**Subject: Environmental Impact Statement – Greater Parramatta, Olympic Peninsula (GPOP) Water Cycle (SSI-74258485) (City of Ryde, City of Parramatta, City of Canada Bay)**

**CPHR comments on the Environmental Impact Statement – Greater Parramatta, Olympic Peninsula (GPOP) Water Cycle (SSI-74258485)**

Figure 6-2 TUFLOW Design case design features

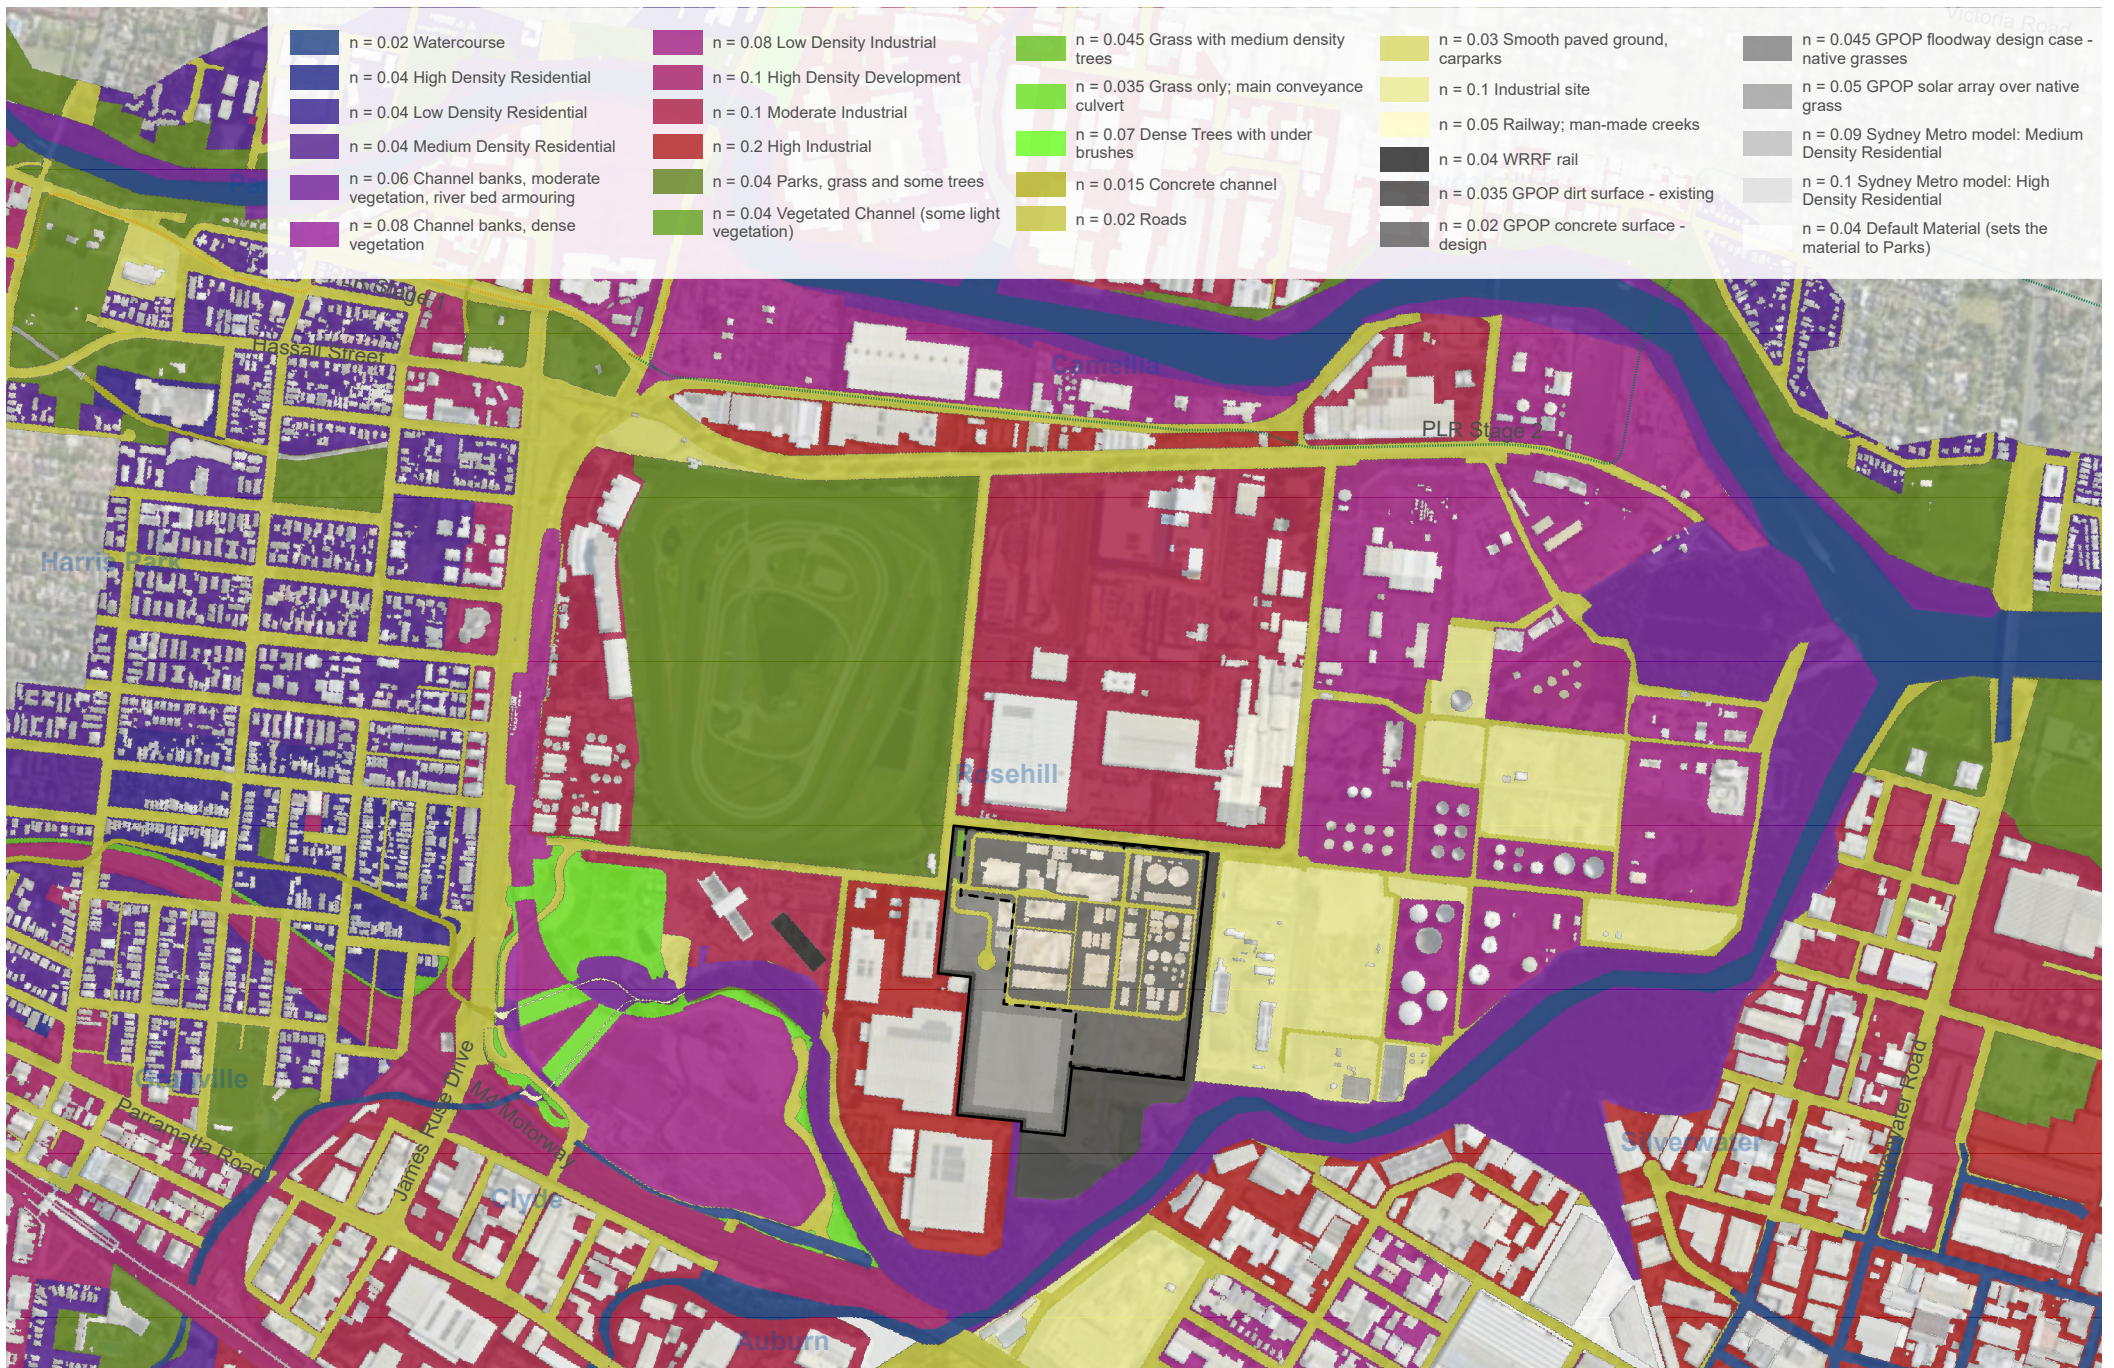
3.	<i>Cumulative impacts of Camelia-Rosehill WRRF site</i>	<p>The FAR states that the proponent intends to fill and regrade the surface of the Camelia-Rosehill WRRF site. This work was previously assessed under a separate planning pathway, through the <a href="#">Review of Environmental Factors for Site Environmental Management Works, Camellia</a> (Sydney Water, October 2024) (October 2024 REF). The FAR has also assumes partial filling of the existing site topography due to a reduced project footprint following determination of the October 2024 REF, consistent with the Amendment REF currently being prepared by Sydney Water</p> <p>The <a href="#">Parramatta River Flood Study</a> (Stantec, 13 June 2024) identifies the WRRF site as providing flood storage (prior to filling) during the 20% Annual Exceedance Probability (AEP) event. The FAR states that the October 2024 REF demonstrated significant flood impacts to neighbouring properties during the probable maximum flood (PMF) as a result of filling the WRRF site. CPHR previously requested that Sydney Water model a scenario using the pre-fill site topography as a base case and compare it with the design case to demonstrate the total impact of the site on flood behaviour. This analysis is not included in the FAR.</p> <p>CPHR advises that cumulative impacts must be considered in accordance with the <a href="#">Flood Risk Management Manual</a>. The Department of Planning, Housing and Infrastructure (DPHI) should be aware of the combined effects of site filling under both the October 2024 REF and the Amended REF (if determined) when assessing this SSI. Further, CPHR also notes that Sydney Metro West has contributed to increased flood levels during the PMF event and DPHI should consider these broader cumulative changes to flood behaviour as part of its assessment.</p> <p><b>Recommended actions:</b></p> <ul style="list-style-type: none"> <li>Revise the FAR to include flood mapping of the WRRF site prior to filling from the October 2024 REF flood assessment and</li> </ul>

<p>provide flood impact mapping comparing this scenario with the design case.</p> <ul style="list-style-type: none"> <li>If the Amendment REF has been determined, revise the FAR to also include flood mapping of the condensed WWRF site footprint prior to filling and include flood impact mapping of the design case compared to this prior filling scenario.</li> </ul>
	<i>Extent and Timing</i>	Response to Submissions

Figure 8-1 Project impact area including indicative construction compounds

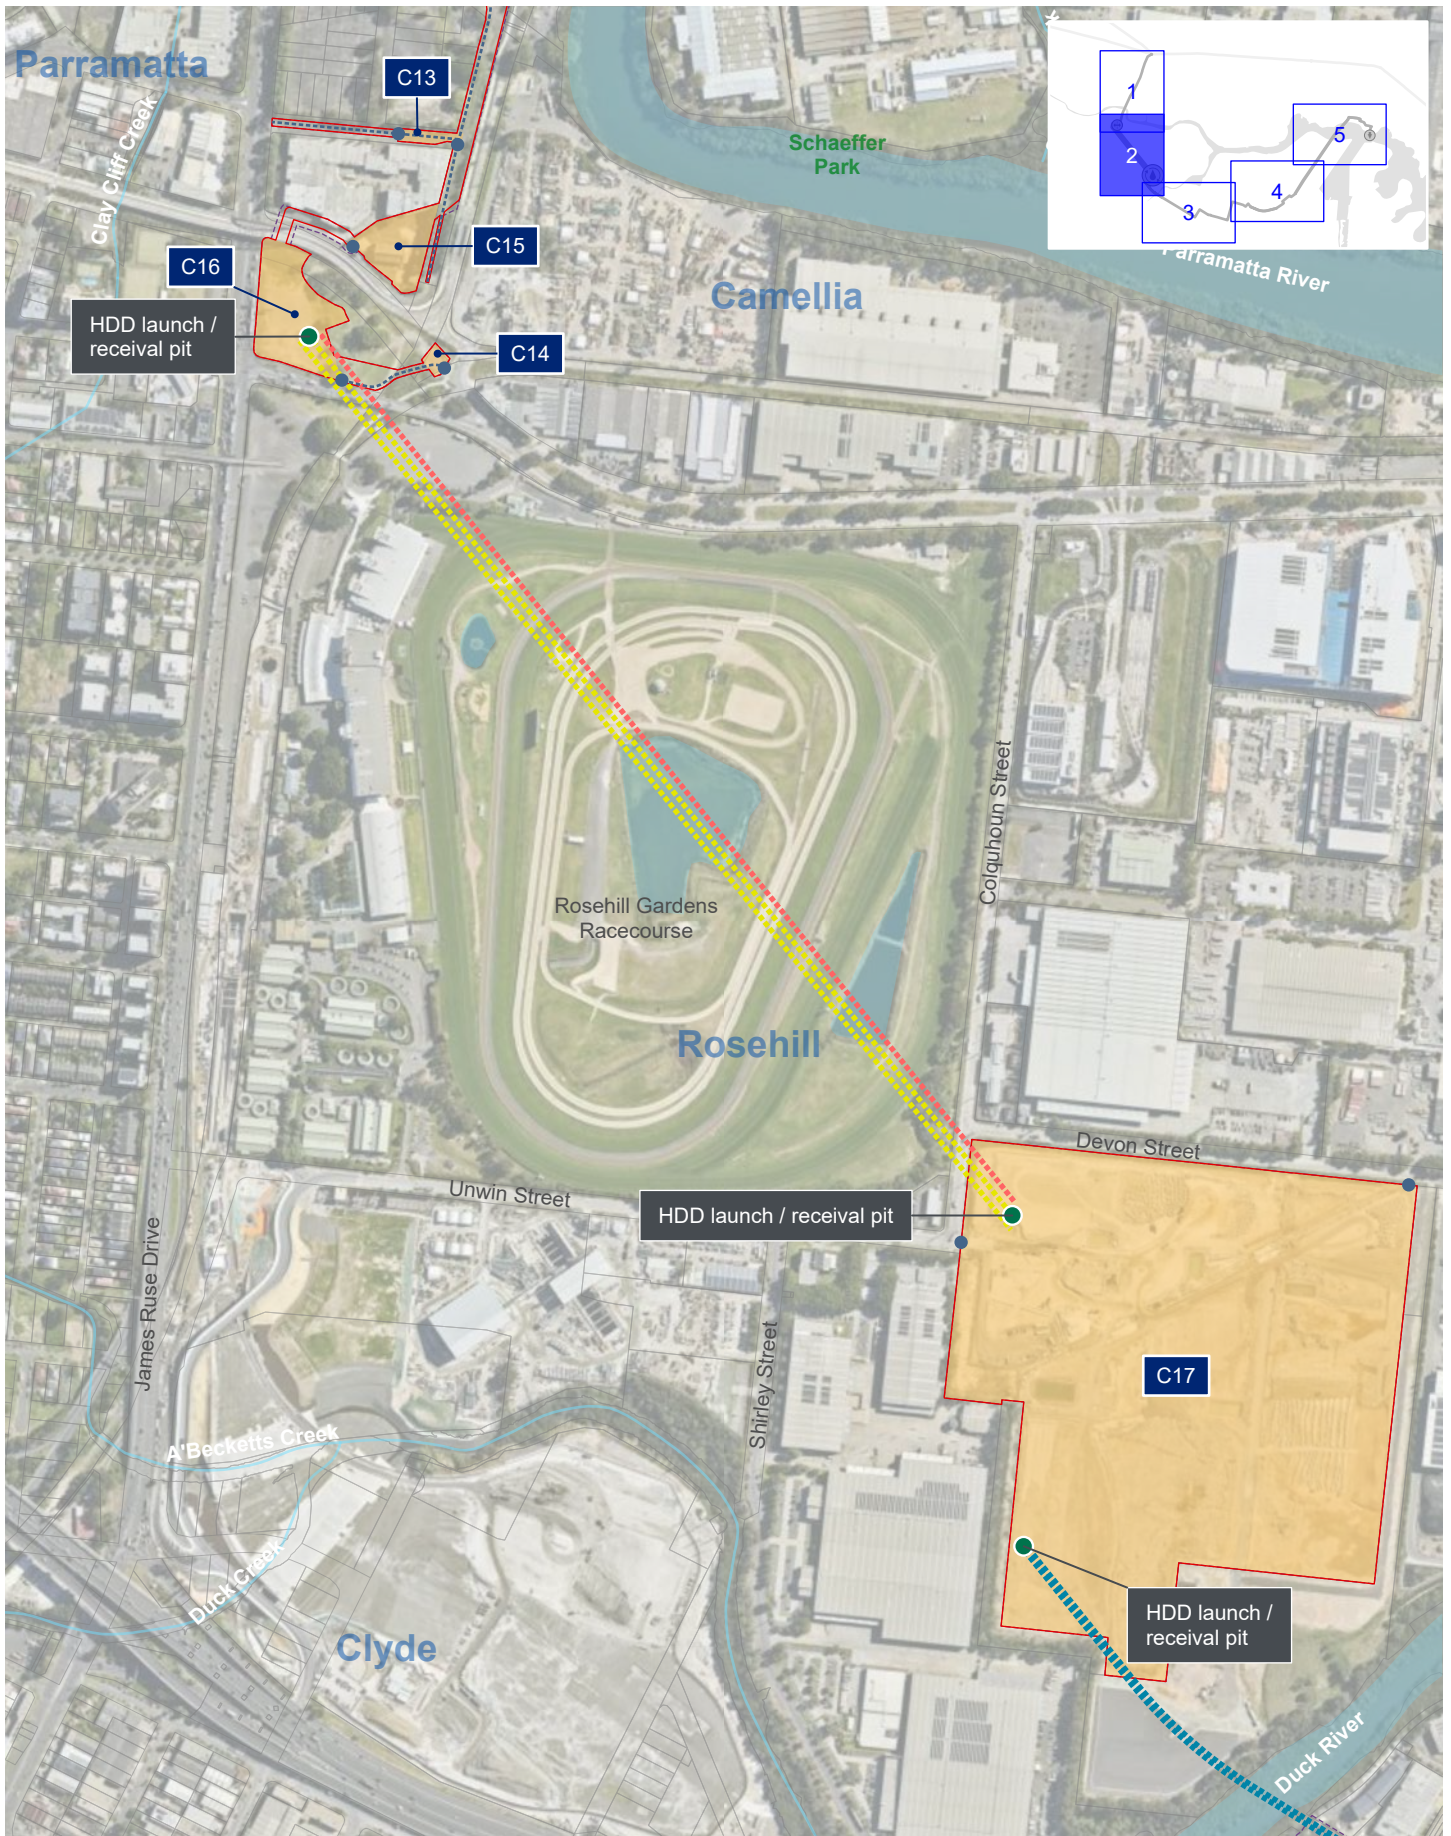
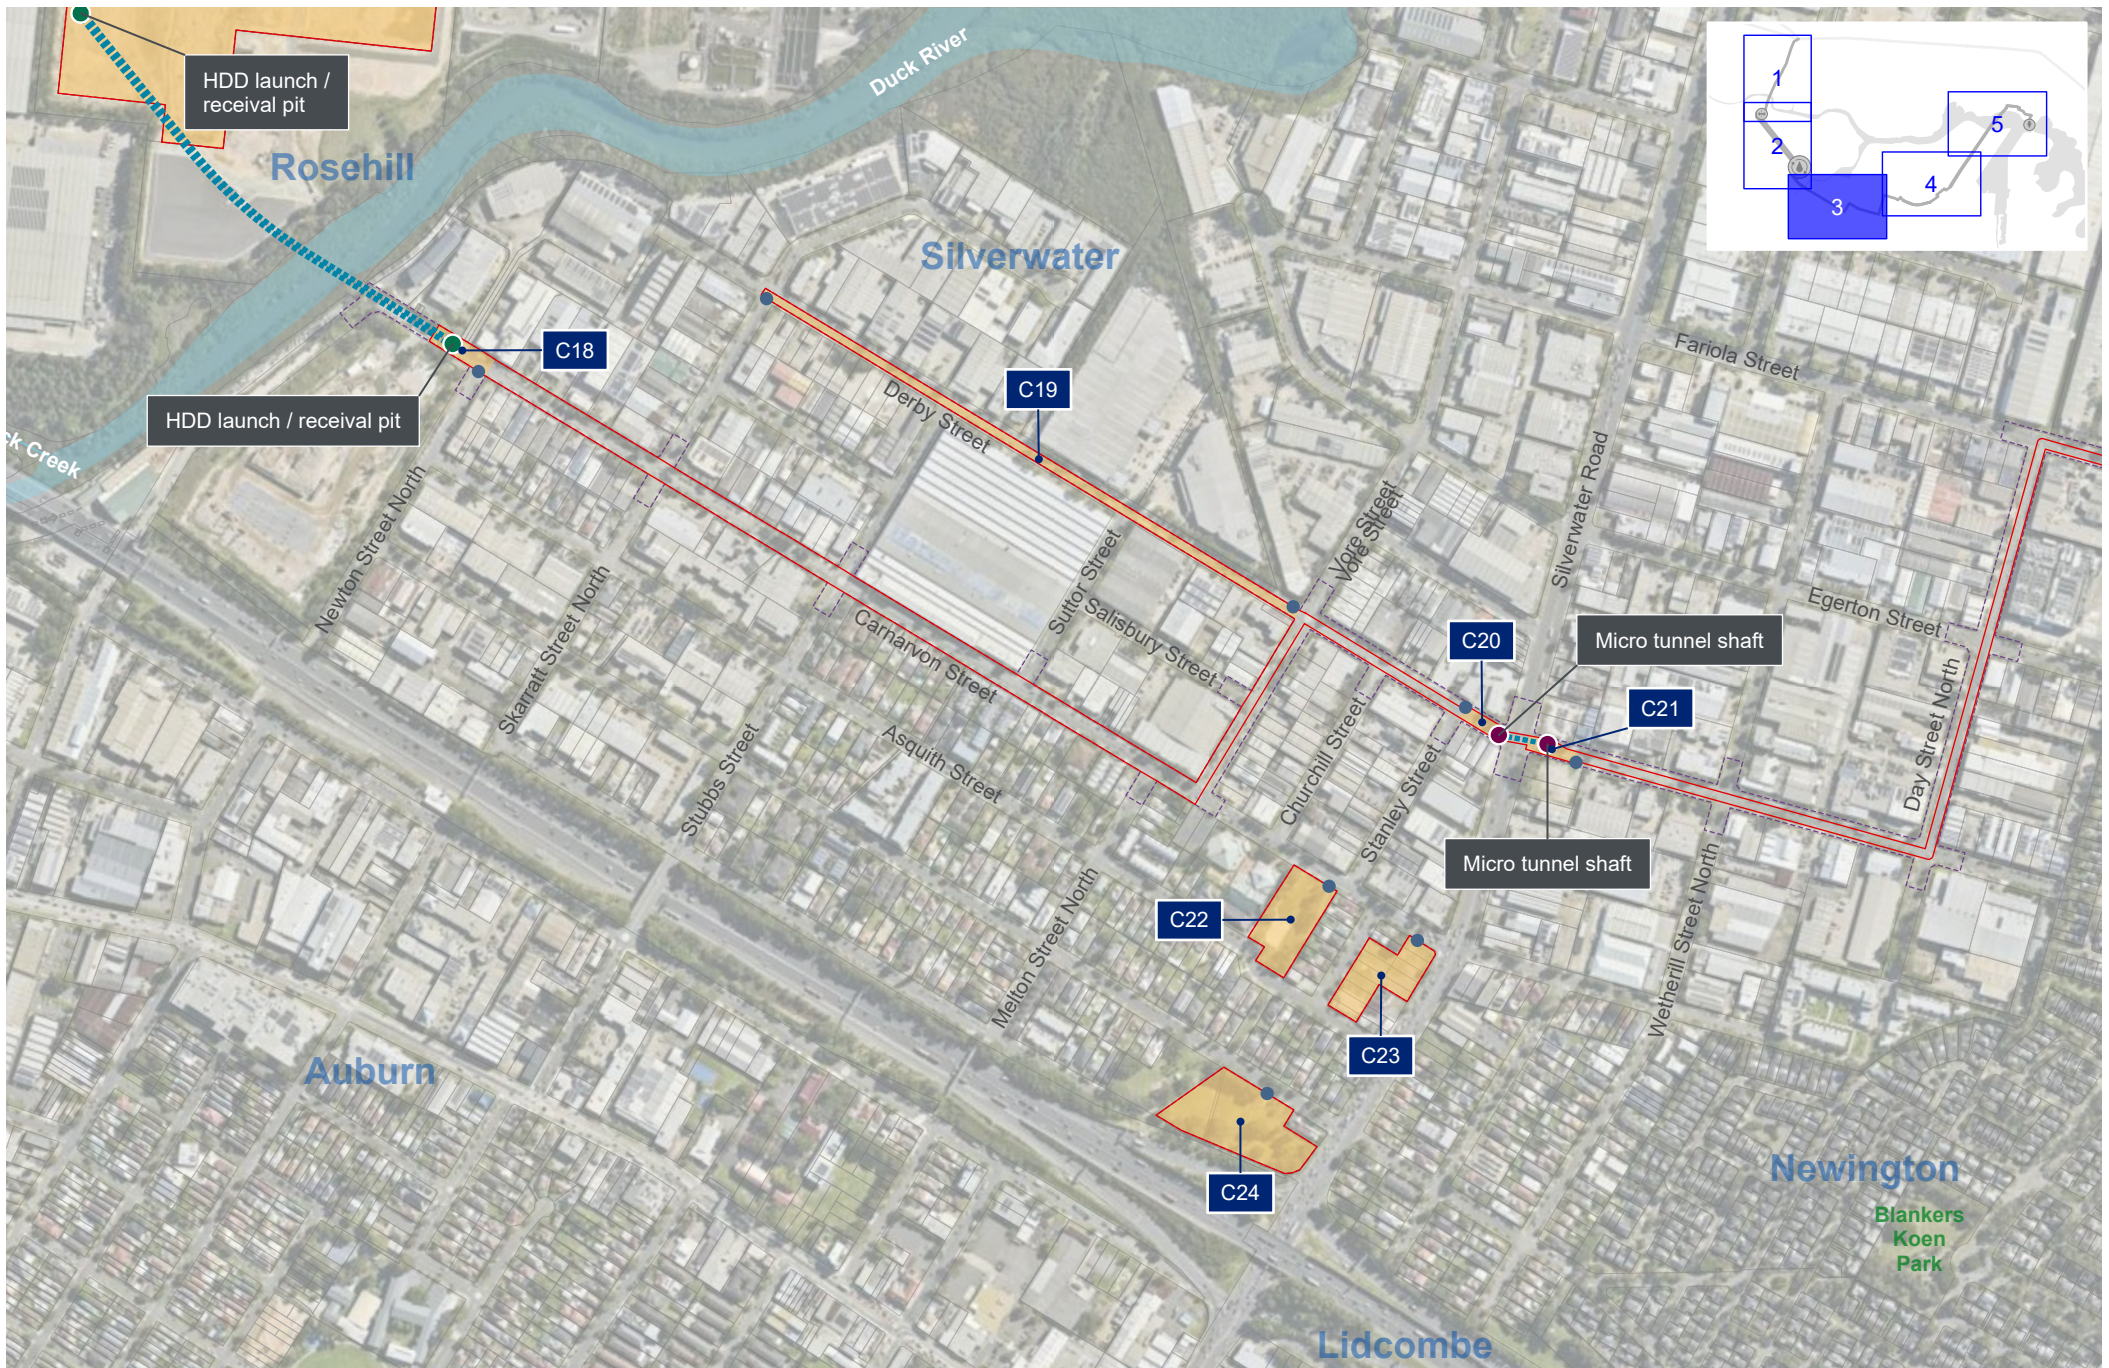
7.	<i>Management of construction flood impacts</i>	<p><i>Section 8 - Construction phase flood impact assessment</i> of the FAR identifies the potential impacts of construction activities on flood behaviour. It identifies that some proposed site compounds are located in areas that experience flooding as frequently as the 20% AEP event, resulting in potential impacts on private properties. CPHR advises that mitigation strategies must be developed for any site compound shown to cause flooding of private property during the 20% AEP or more frequent events.</p> <p>As CPHR does not have a post-approval role in document review, the proposed flood mitigation strategies must be provided at the Response to Submissions stage, prior to determination.</p> <p><b>Recommended action:</b></p> <p>Provide mitigation strategies in a revised FAR to address the flood impacts associated construction activities and site compounds where impacts to private property are identified to occur in the 20% AEP event (or more frequently).</p>
